# City of Albuquerque

RE: FAA ENVIRONMENTAL BUILDING, PROJECT NO.3216

RE: REVISED GRADING PLAN OF FAA FLIGHT SERVICE STATION RECEIVED  
APRIL 29, 1987 FOR BUILDING PERMIT APPROVAL (N-16/D6) (PROJECT  
NO. 3259)

RE: DRAINAGE PLAN FOR FAA FLIGHT SERVICE STATION  
(N-16/D6) RECEIVED APRIL 8, 1987

TITLE
GRADING PLAN

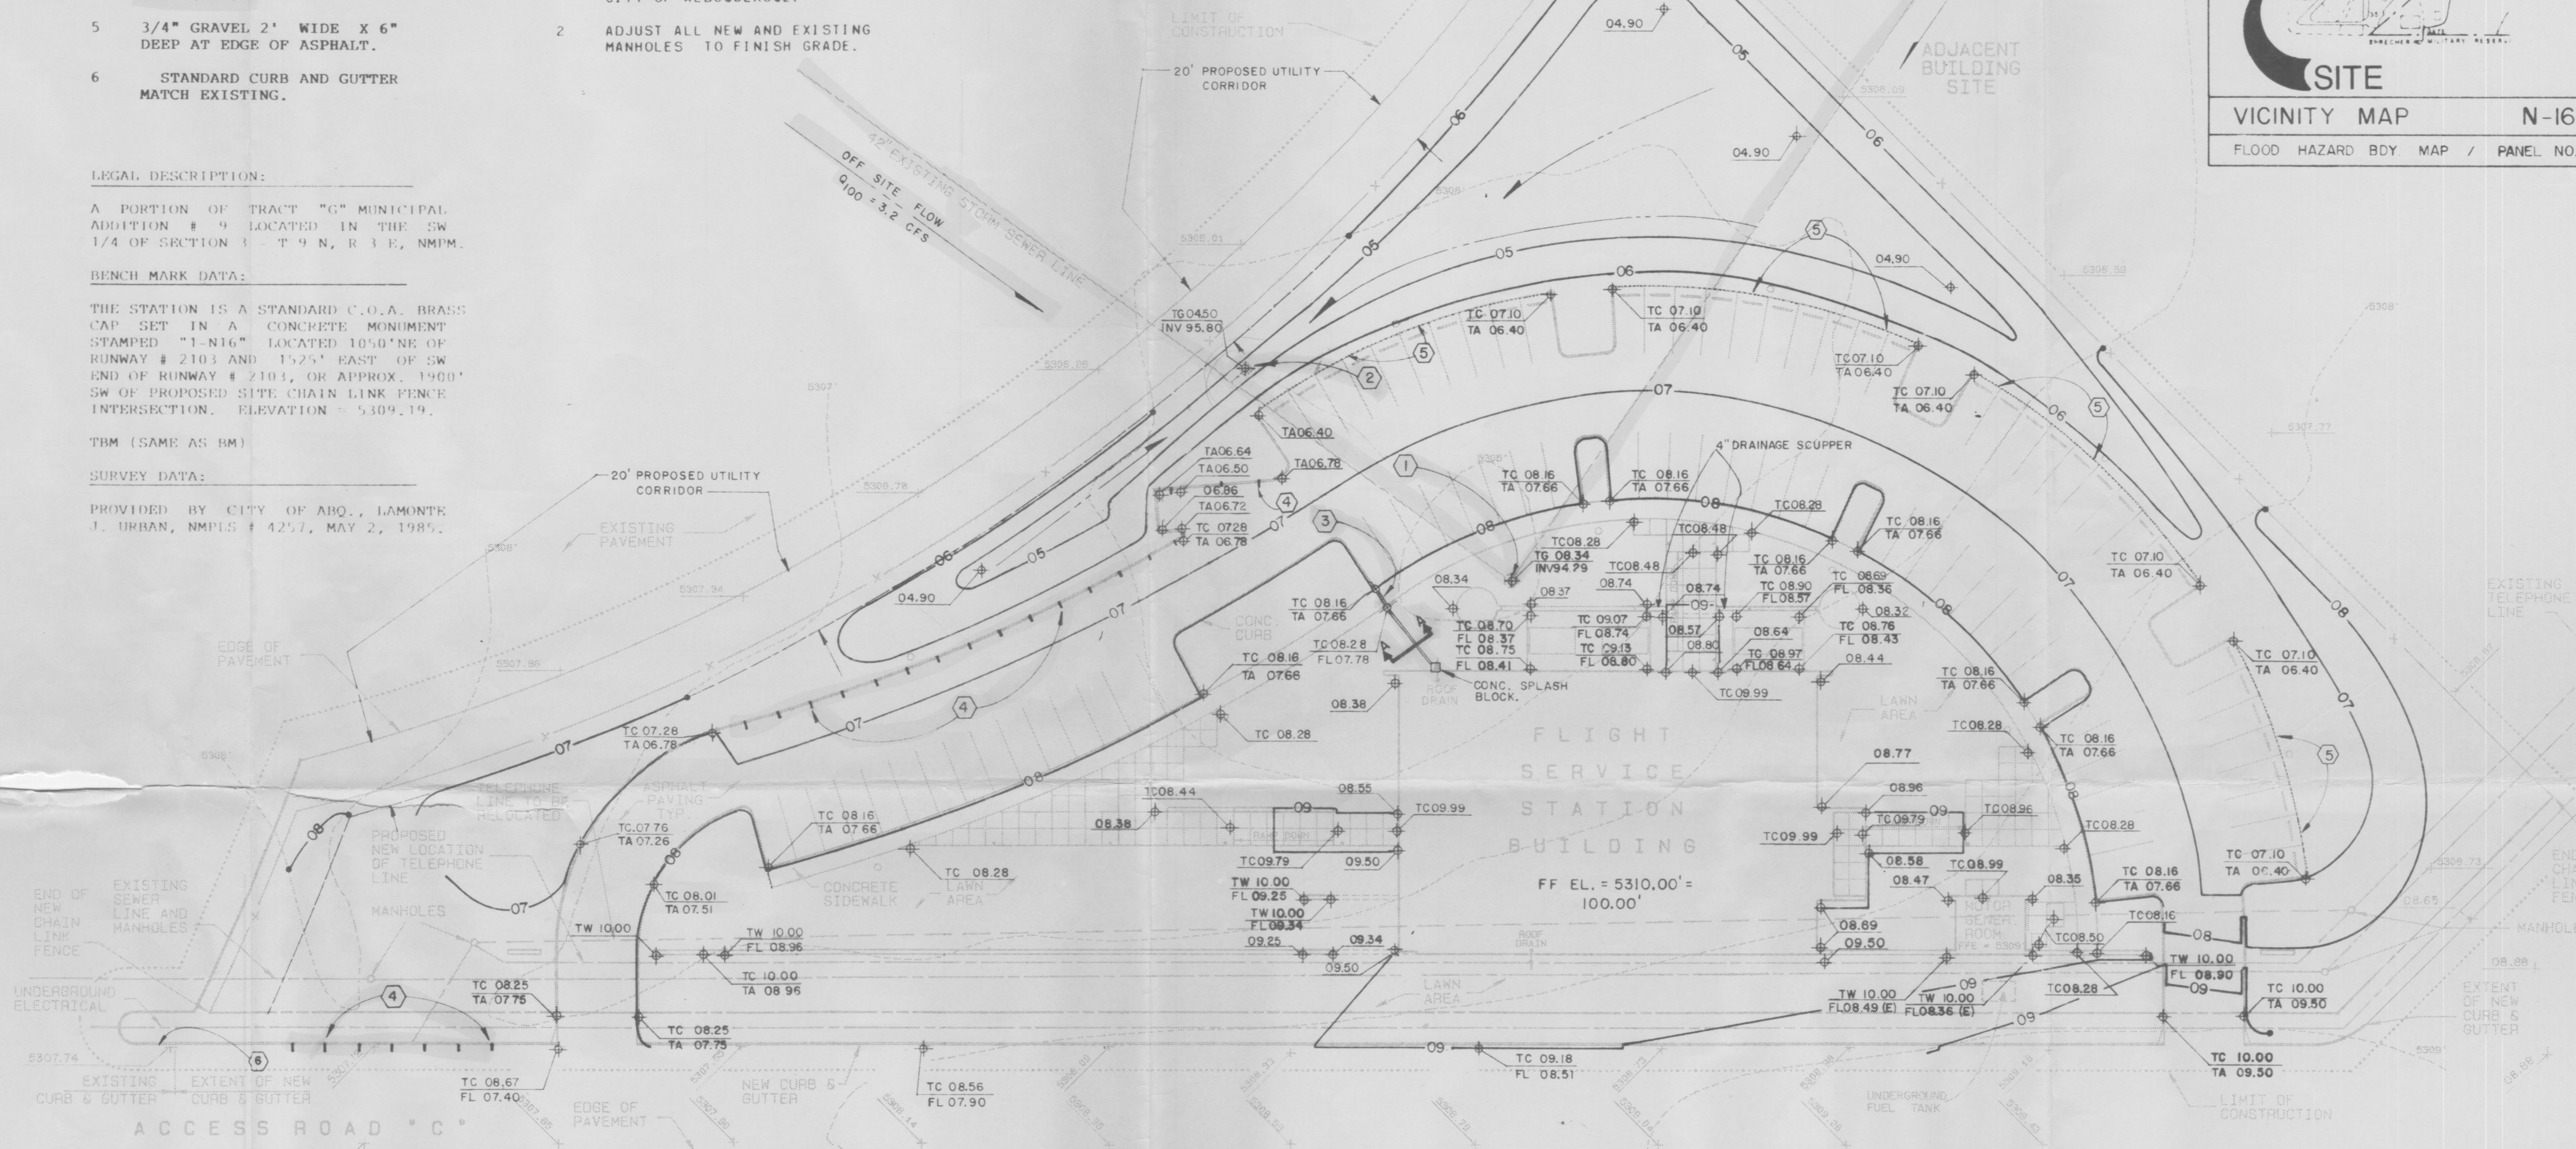
1. Please give a detail of the new inlet.
2. Will the existing storm drain inlet be used or abandoned?
3. Please show that positive flow can be accomplished in the ponds.
4. Please address sediment control for the proposed inlet.

The above referenced submittal, revised April 24, 1987, is approved for Building Permit sign-off by Hydrology. Include this approved plan with the construction sets routed for sign-off.

Prior to Certificate of Occupancy approval by Hydrology, the storm drain connection and catch basin, to be constructed under the work order process, must be in place and accepted.
